**KIRKLEES METROPOLITAN COUNCIL
INVESTMENT & REGENERATION SERVICE**

DELEGATED DECISION TO DETERMINE PLANNING APPLICATIONS

Reference No:	2025/62/93208/W
Site Address:	Copley House Farm, Slaithwaite Road, Meltham, Holmfirth, HD9 5PT
Description:	Removal of existing porch and erection of single storey front extension, including conversion of garage to habitable accommodation and associated alterations
Recommending Officer:	Joanna Rednall

DECISION – CONDITIONAL FULL PERMISSION

south east elevation - front

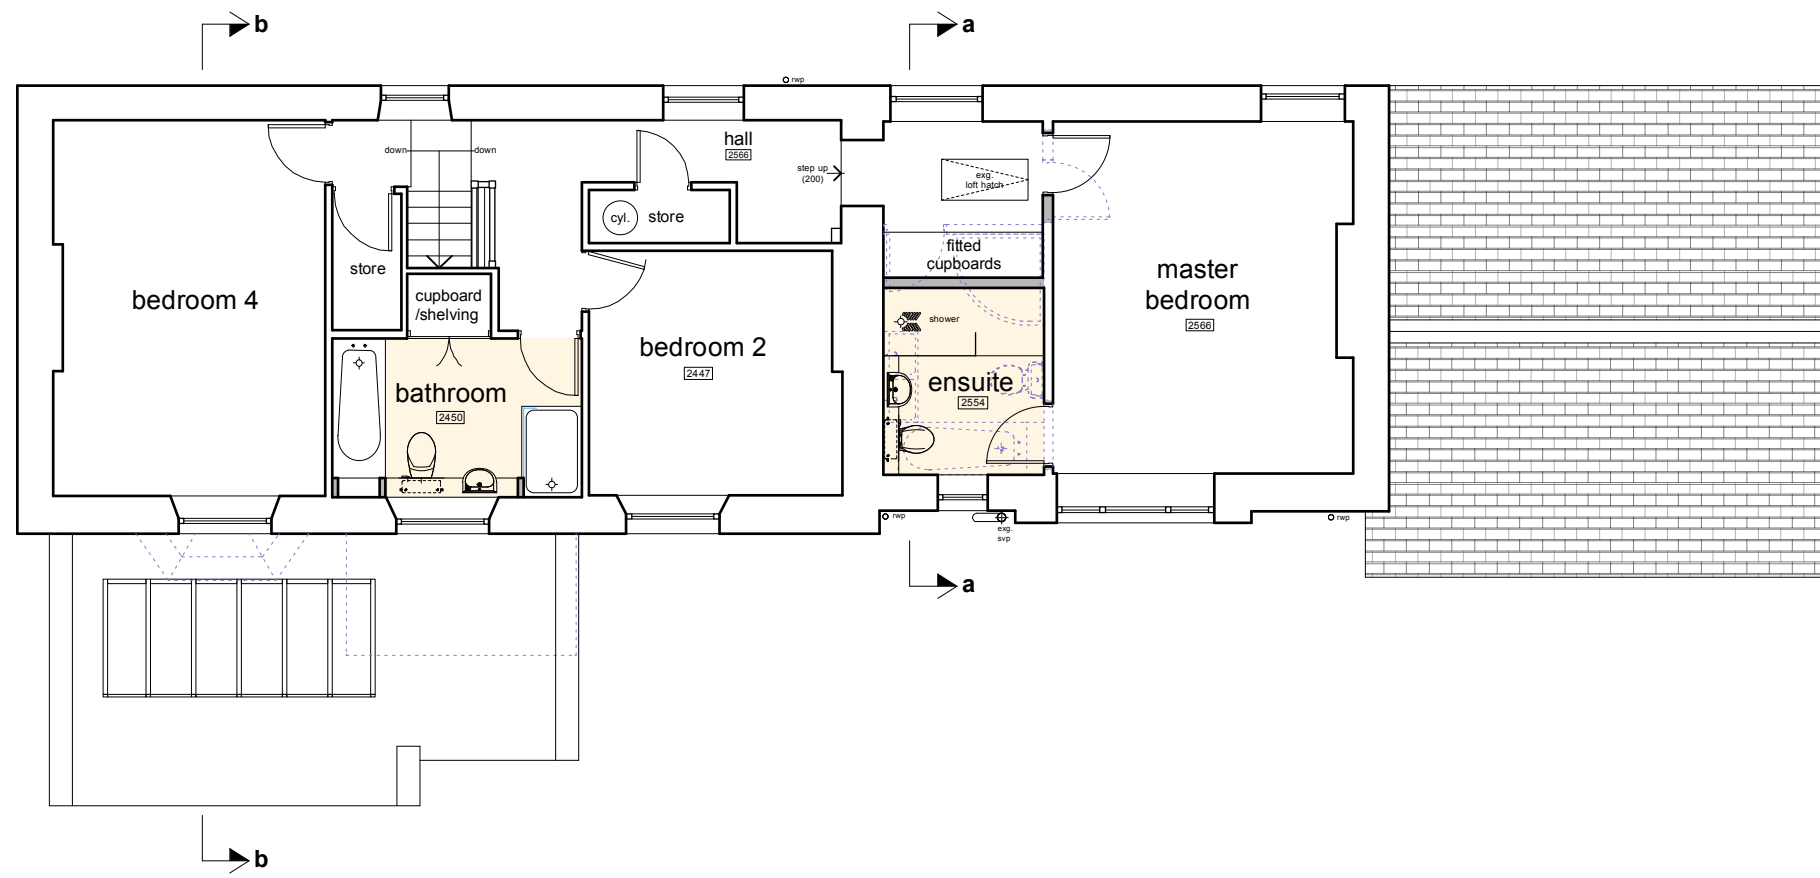
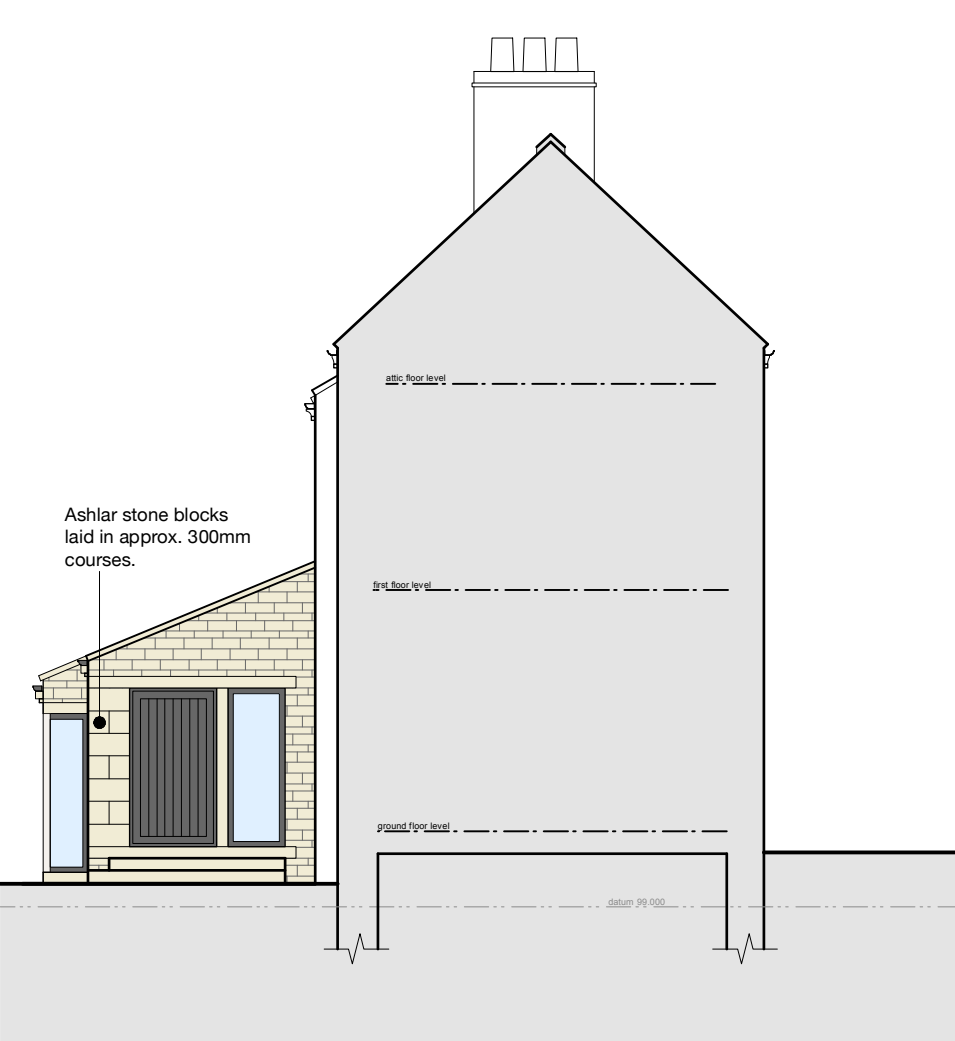
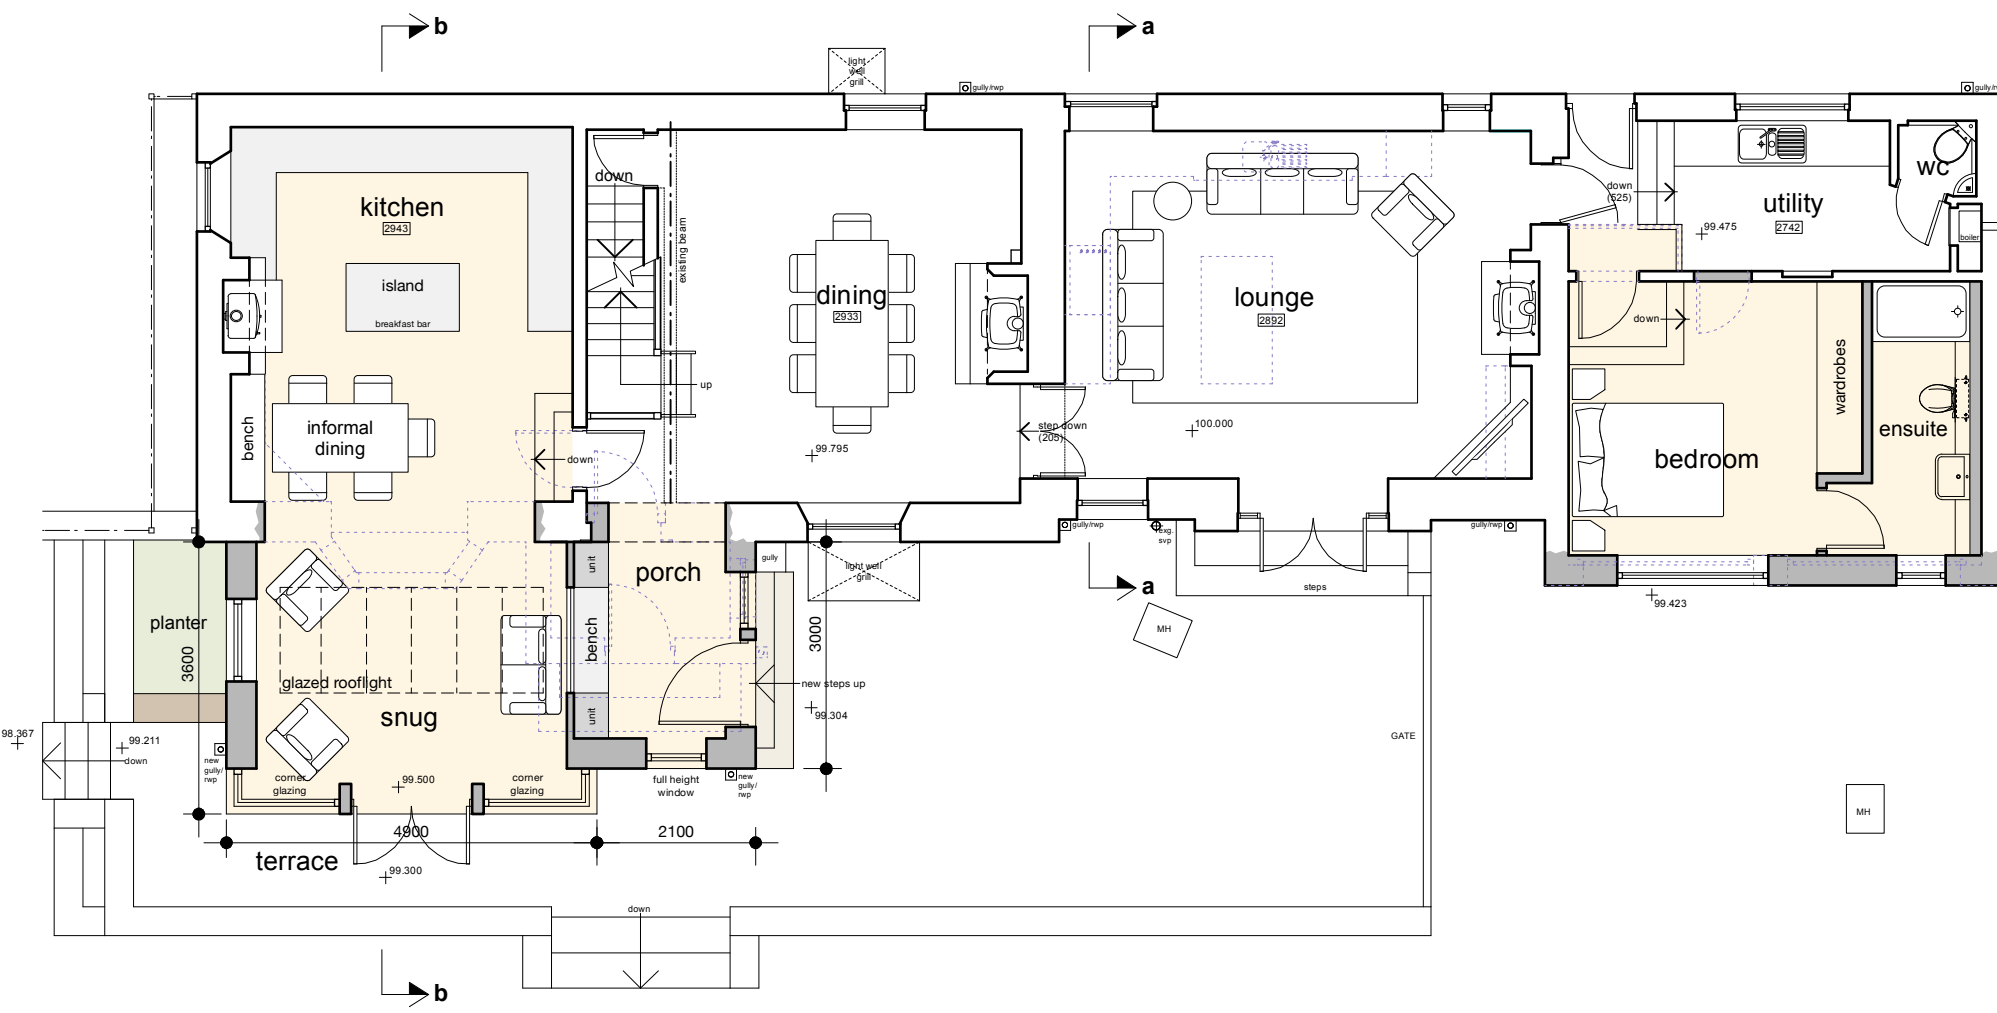
Officers raised concerns regarding the proposed openings, noting that they did not reflect the design of the original house. The applicant's agent submitted a design justification statement on 21st January 2026, which is considered and addressed in the Officer Report.

In this case, the proposal is set back approximately 16 metres from the highway and would be well screened by the existing wall and hedging that separate the site from Slaithwaite Road. As set out in the principle section above, officers consider that, by reason of its modest scale, the proposal would represent a subservient addition to the original building given the context it would be sited and viewed. During the course of the application, officers raised concerns with the applicant's agent in relation to aspects of the design of the extension, including the window arrangement, and a design justification was subsequently submitted in response.

In respect of the garage conversion, the existing double garage doors would be replaced with infill walling incorporating ashlar string course detailing to reflect the design of the proposed front extension. Two windows are proposed on the front elevation and due to their proportions and the use of matching materials, would appear in keeping with the host dwelling and would result in an acceptable visual impact.

- Maximising key views: The property benefits from uninterrupted views to the south. The proposed glazing is intentionally designed to allow these views to be fully appreciated from the new extension, enhancing the enjoyment and usability of the space.
- Improving natural daylight: The existing lounge, proposed to be repurposed as the kitchen-dining family room, is currently a dark space that relies heavily on artificial lighting. The extension, together with the carefully positioned rooflights, has been specifically designed to admit high levels of natural light into the new accommodation and through to the existing room. This reduces reliance on artificial lighting, supports

- Avoiding poor-quality, oppressive design: Reducing glazing to create a more solid “box-like” structure on the front elevation would result in a heavy, visually dominant form that would neither represent good design practice nor contribute positively to residential amenity.

- Replacing previous add-ons: The proposed extension replaces the existing porch, an incongruous, non-original addition, and the existing bay window, which itself does not follow the proportions or detailing of the other windows on this part of the elevation. The proposal therefore provides an opportunity to rationalise and improve the architectural coherence of the façade.

- High-quality detailing in keeping with the host dwelling: The extension has been designed with close attention to the architectural language of the existing property, incorporating water-tabling, stone corbels, a stringcourse detail, and ashlar mullions, heads, and cills. These features ensure that the proposed glazing sits comfortably within a well-considered and contextually appropriate design.

Taking the above into account, and noting that the proposal would replace an existing porch with a more visually cohesive addition, officers consider that, on balance, the proposal would result in an acceptable visual appearance. The development would allow increased levels of natural light and would be largely screened from public vantage points. Overall, the scale would remain subordinate to the original dwelling and would not appear unduly out of keeping or incongruous on the principal elevation when assessed in the context of the host property.
